Consultation Response from KC, Conservation and Design
2020/90630 Old Town Hall, Lewisham Road, Slaithwaite, Huddersfield, HD7 5AL
Erection of single storey side extension (within a Conservation Area)
Date Responded: 01/04/20 Responding Officer: Craig McHugh Responding Ref: Slaithwaite

Proposed side elevation (1:100)

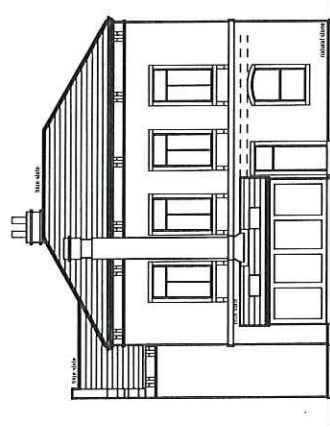
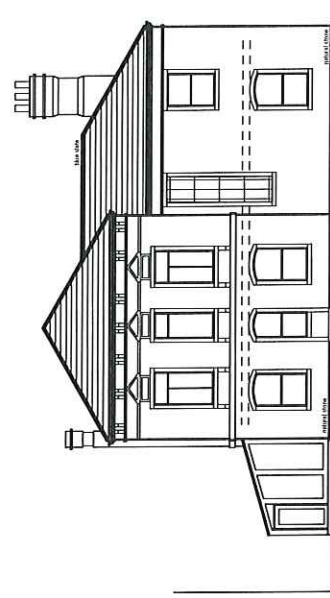
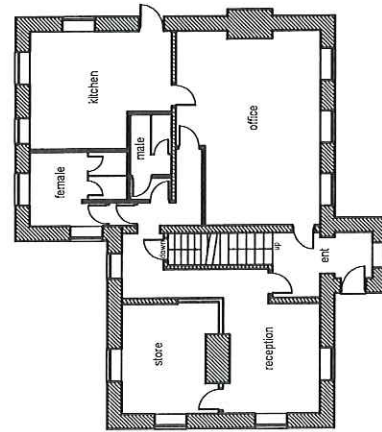
There is no concern in principle with an orangery / conservatory extension to the building. However, the proposed location built around the external chimney stack would partly obscure an important detail of the existing building. The proposed design utilising a simple lean-to extension with an oak frame (presumed to be oiled) is also heavy and overly plain for a building with such a lively style.

- The extension is shifted further north, away from the chimney stack
- The orangery/ conservatory is of a more traditional design with a lighter appearance and traditional materials e.g. painted timber or metal frame built on a stone plinth to match the main building
